Kerry National Roads Office
Kerry County Council
The Island Centre
Castleisland
Co. Kerry

Date: 27 July 2026

Re: Proposed development N70 Waterville to Ballybrack Road Improvement Scheme
Townlands of Waterville, Ballybrack and Eightercua, Co. Kerry

The following Further Information is requested:

Figure 5-4 Proposed Footbridge at Currane River

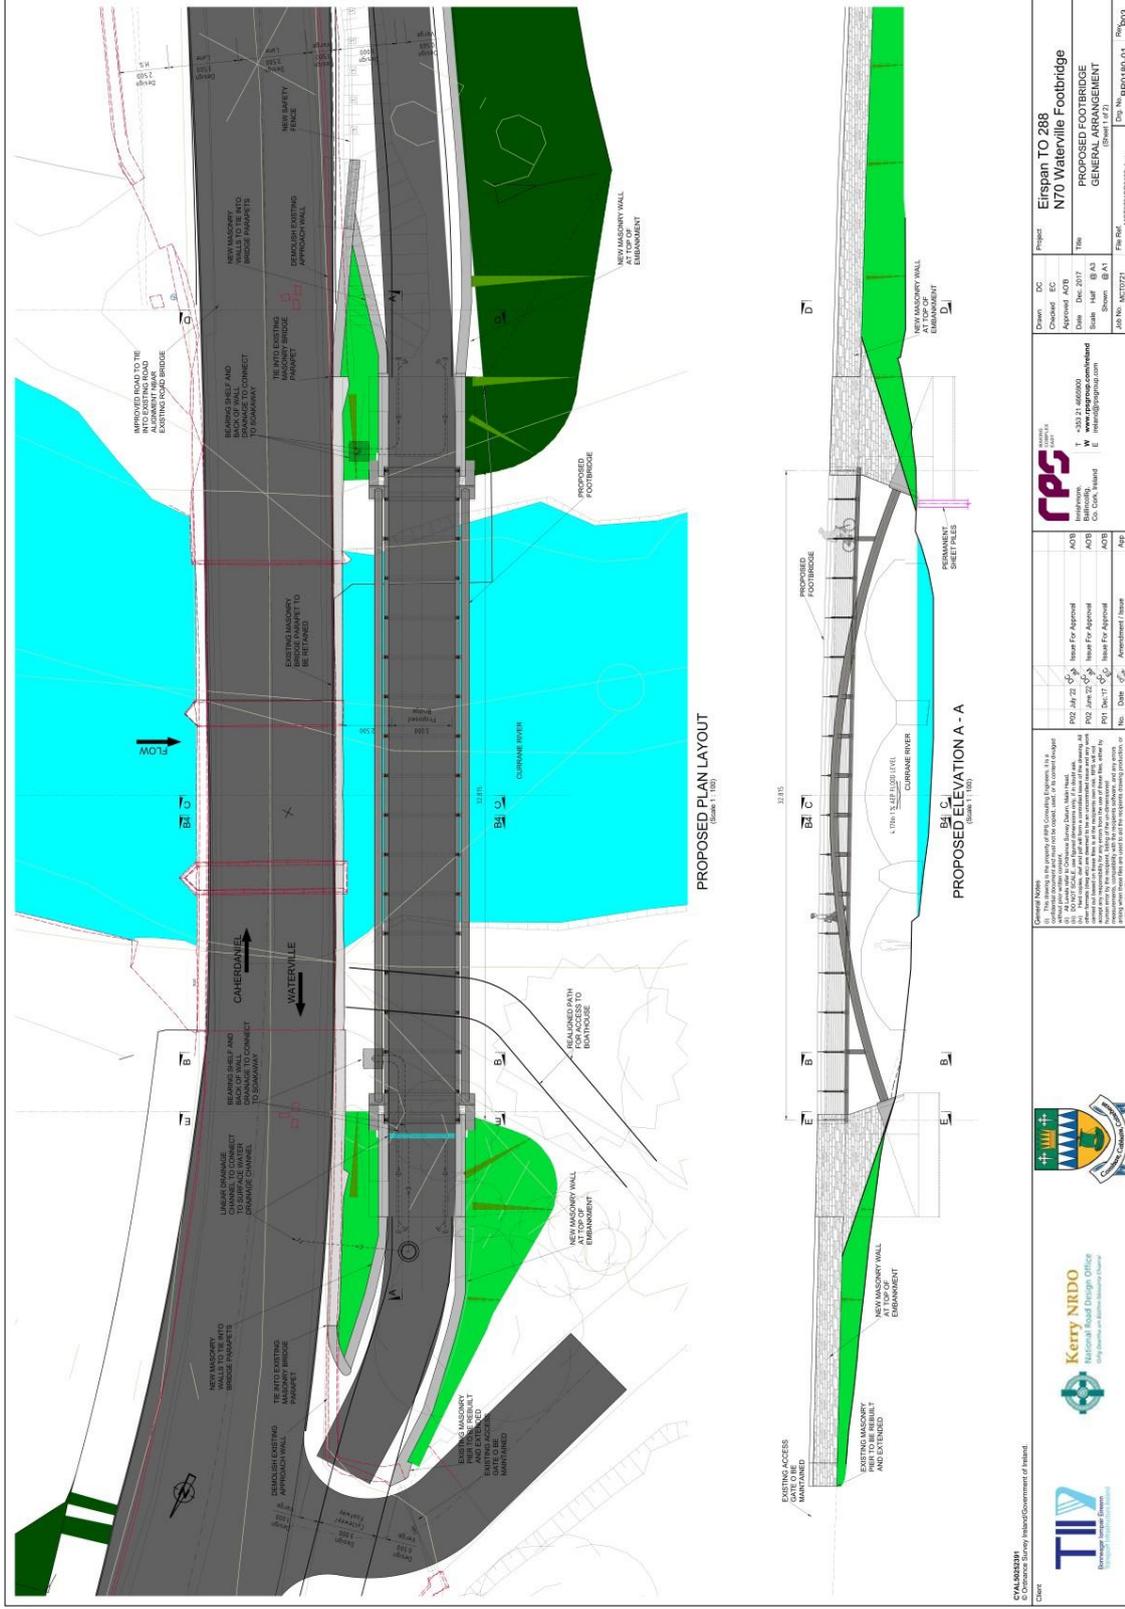
1. Following a review of the applicant documentation, it is considered that sufficient detailed information has not been received to show precise arrangements at Waterville Bridge. Therefore, the applicant shall provide drawings (plans, sections and elevations) and a construction method for the proposed scheme at Waterville Bridge and adjoining area detailing in particular:

- a) the design and construction method of the proposed footbridge and its associated supporting structures,
 - b) location and extent of any proposed instream works,

- e) arrangements (temporary and permanent) for access under the northern arch of Waterville Bridge and interaction with proposed footbridge.
2. Following a review of the applicant documentation, it is considered that sufficient detailed information has not been received to show the precise impacts of the proposed development on Ballinskelligs Bay and Inny Estuary Special Area of Conservation (SAC) (000335) and on Killarney National Park, Macgillycuddy's Reeks and Caragh River Catchment SAC (000365). Therefore, the applicant shall provide the following information to enable a full and
